**Application by Five Estuaries Offshore Wind Farm Limited (Ltd) for an Order Granting Development Consent for a new offshore windfarm, Five Estuaries, with up to 79 wind turbine generators, offshore substation Platforms and electricity transmission infrastructure.**

**Examination Timetable – Deadline 4 – The Examining Authority’s (ExA’s) written questions and requests for information, the ExA’s Second Written Questions (ExQ2).**

**NS.2.06: Depth of cable burial within the export cable corridor (ECC)**

Figure 2.1: Overview of area of interest for NIP.

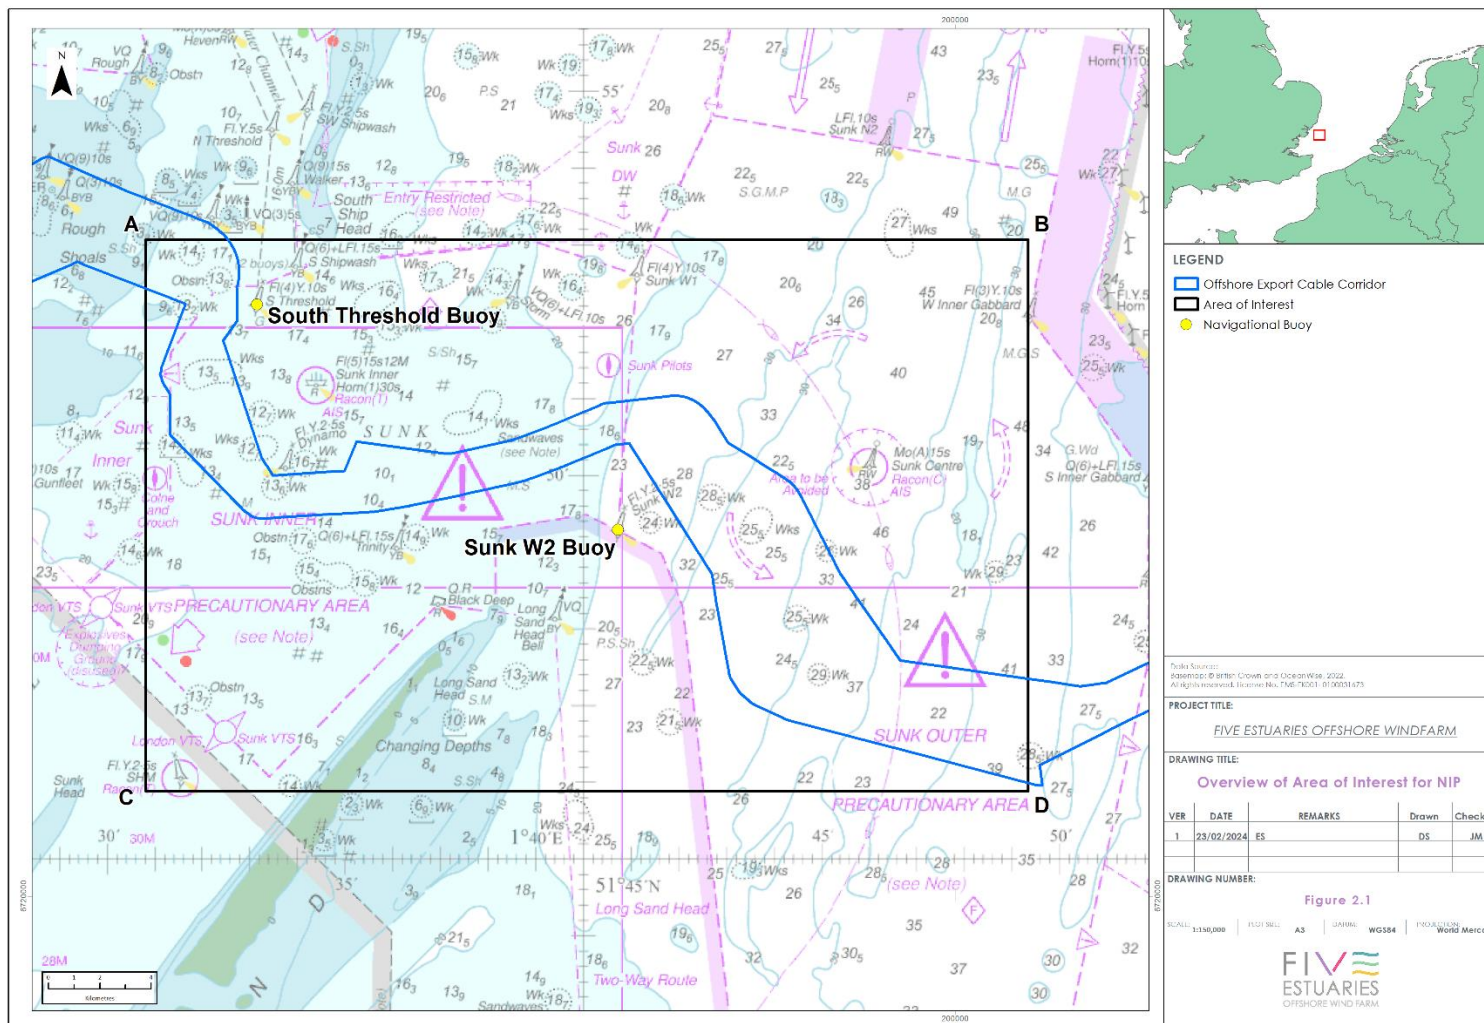
As stated in our Written Representation (REP1-065) MCA welcomes the projects use of a Navigation Installation Plan (NIP) for additional management of the installation of the offshore Export Cable Corridor (ECC). It is noted that the applicant has referred the specific burial depth to be informed by Cable Specification and Installation Plan (CSIP), and as such has not yet committed to a specified depth crossing the deep-water routes (see outline CSIP, APP-242).

As other stakeholders have commented, any cables including any protections such as rock armour, would need to be 22 metres below Chart Datum in order to allow future vessels with a draught of 20 metres to use the routes. Therefore, on this point, we would agree with the key stakeholders that the consensus of 22m below chart datum is appropriate.
